SECTION 4.55 DA
MODIFICATION

URBNSURF SYDNEY
SYDNEY OLYMPIC PARK, NSW

SECTION 4.55 DA MODIFICATION

JULY 2026

DRAWING
ILLUSTRATIVE MASTERPLAN

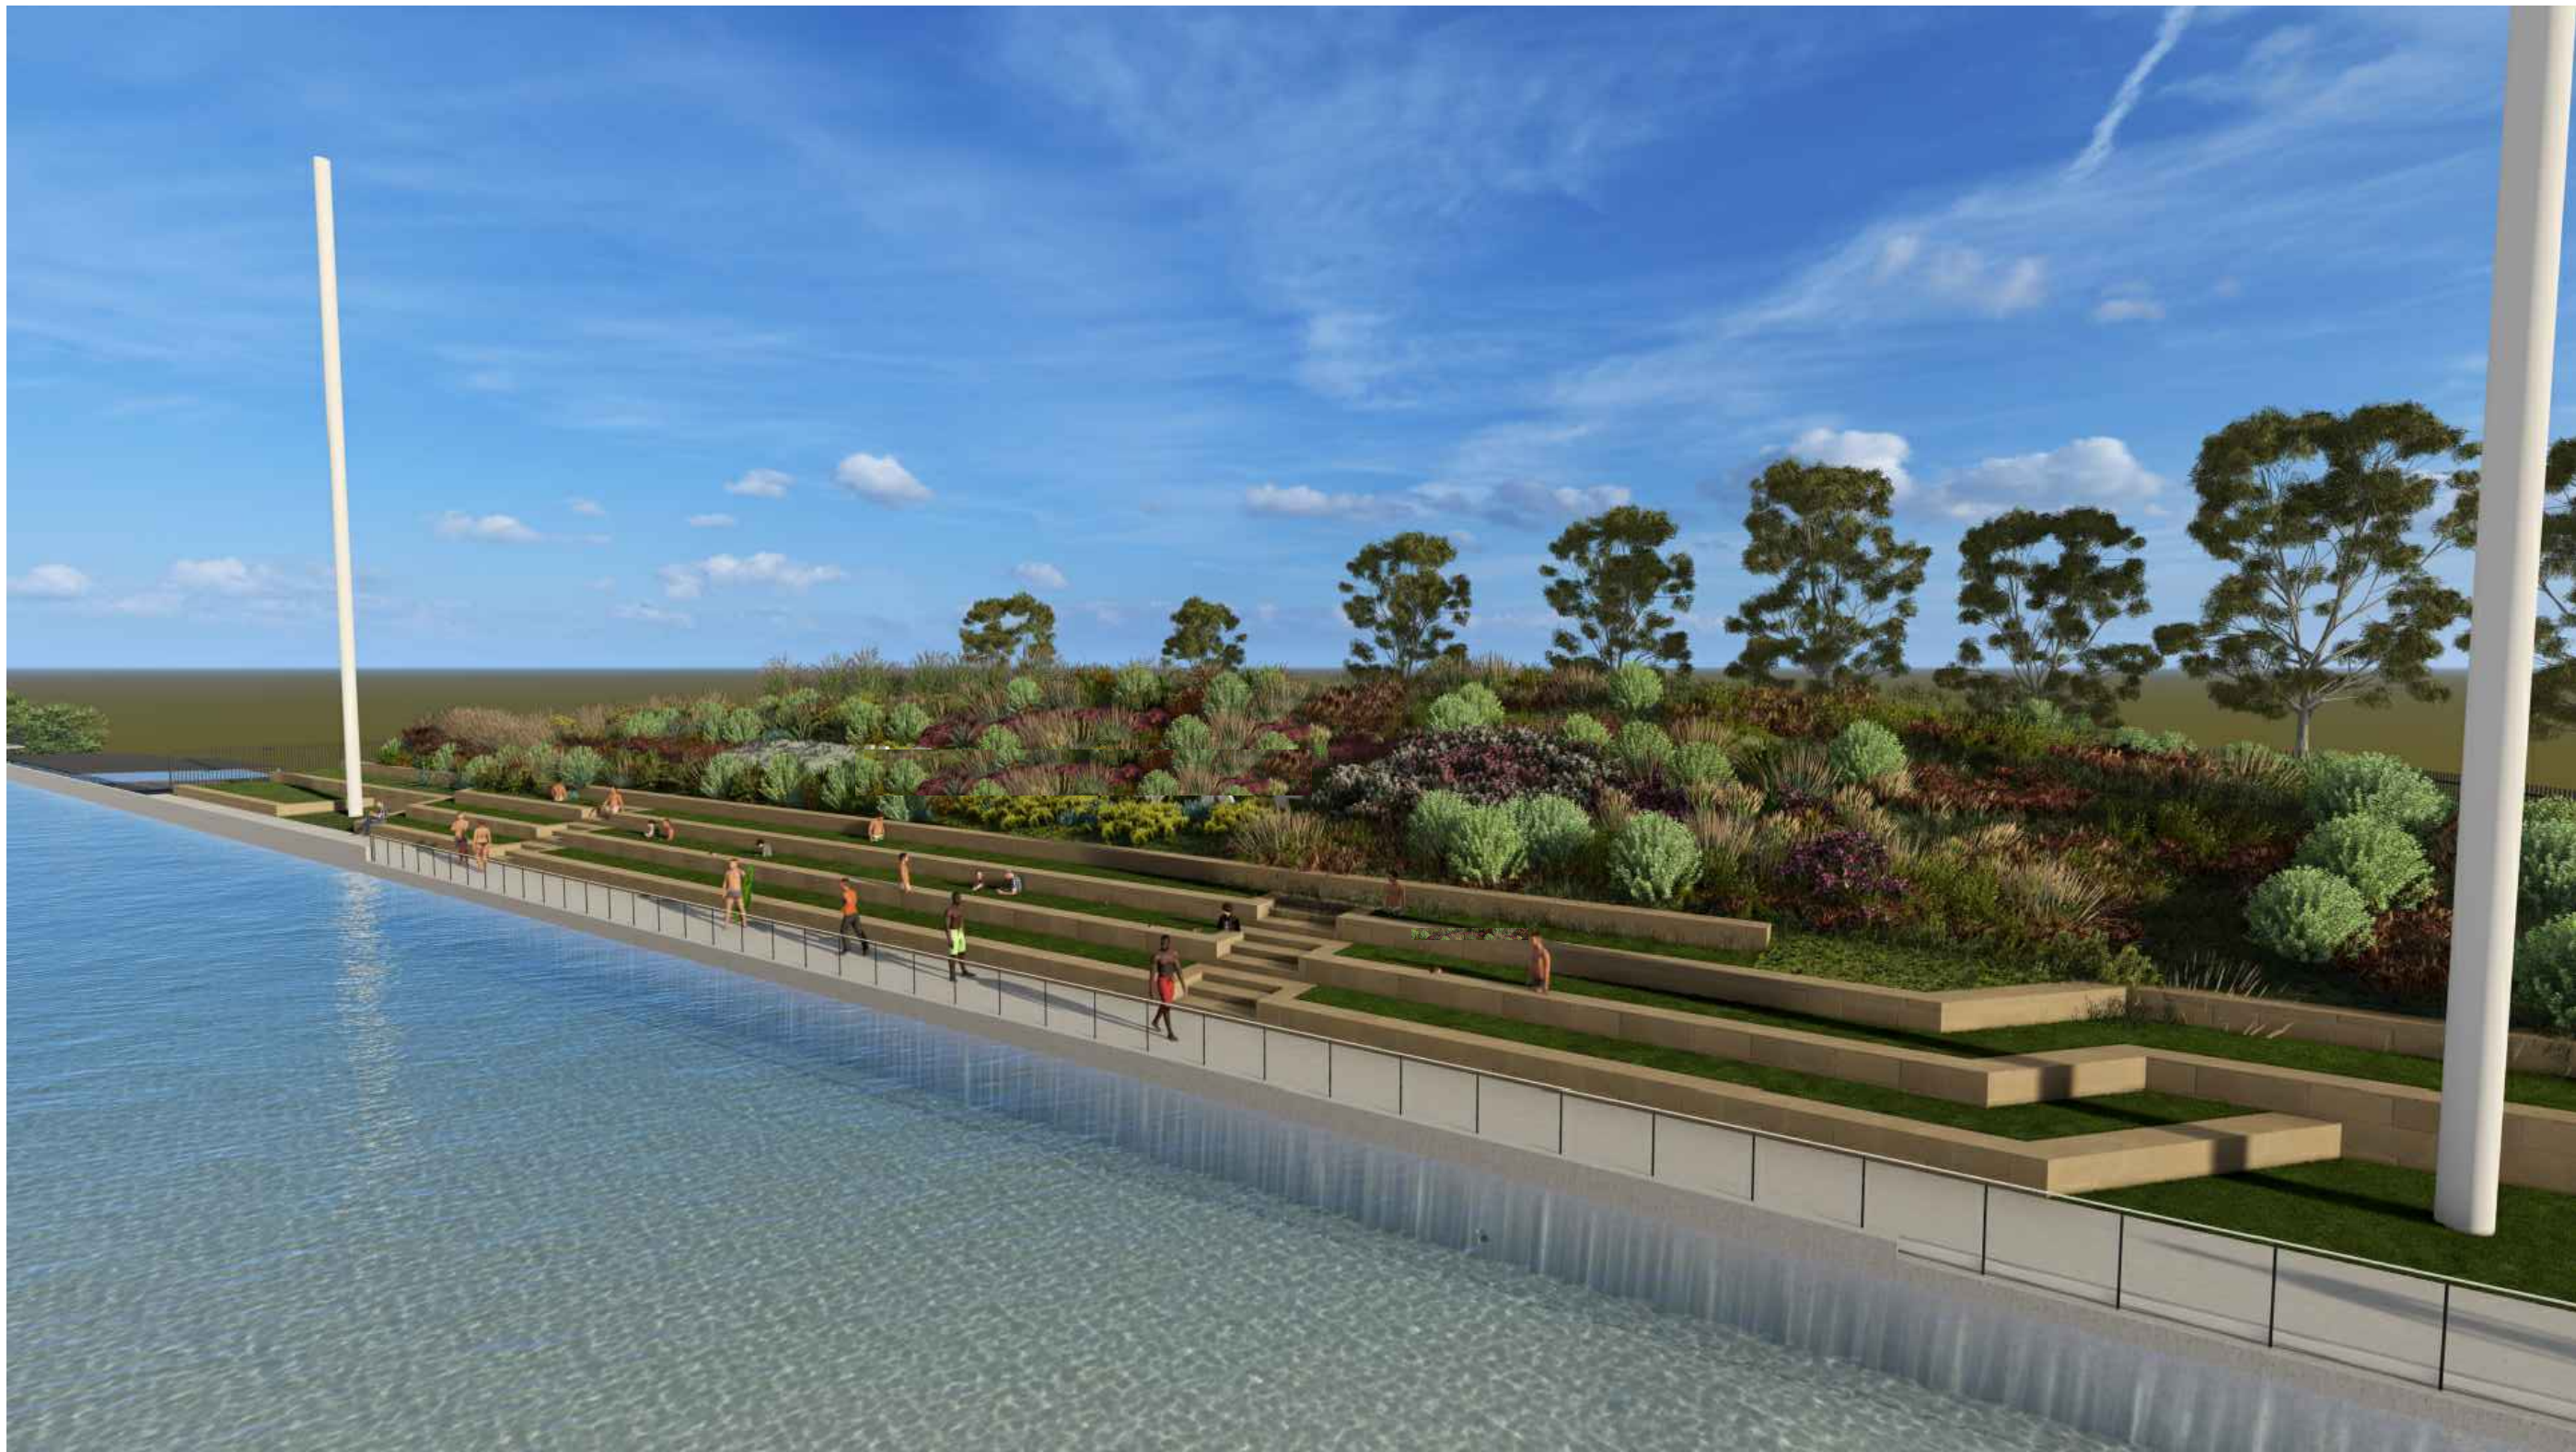
Design Change 1: Playground area replaced with lawn space (Landscape)
- B

Design Change 2: Kids pool replaced with lawn space (Landscape)
- C

Design Change 3: Revised Eastern Hill landscape design
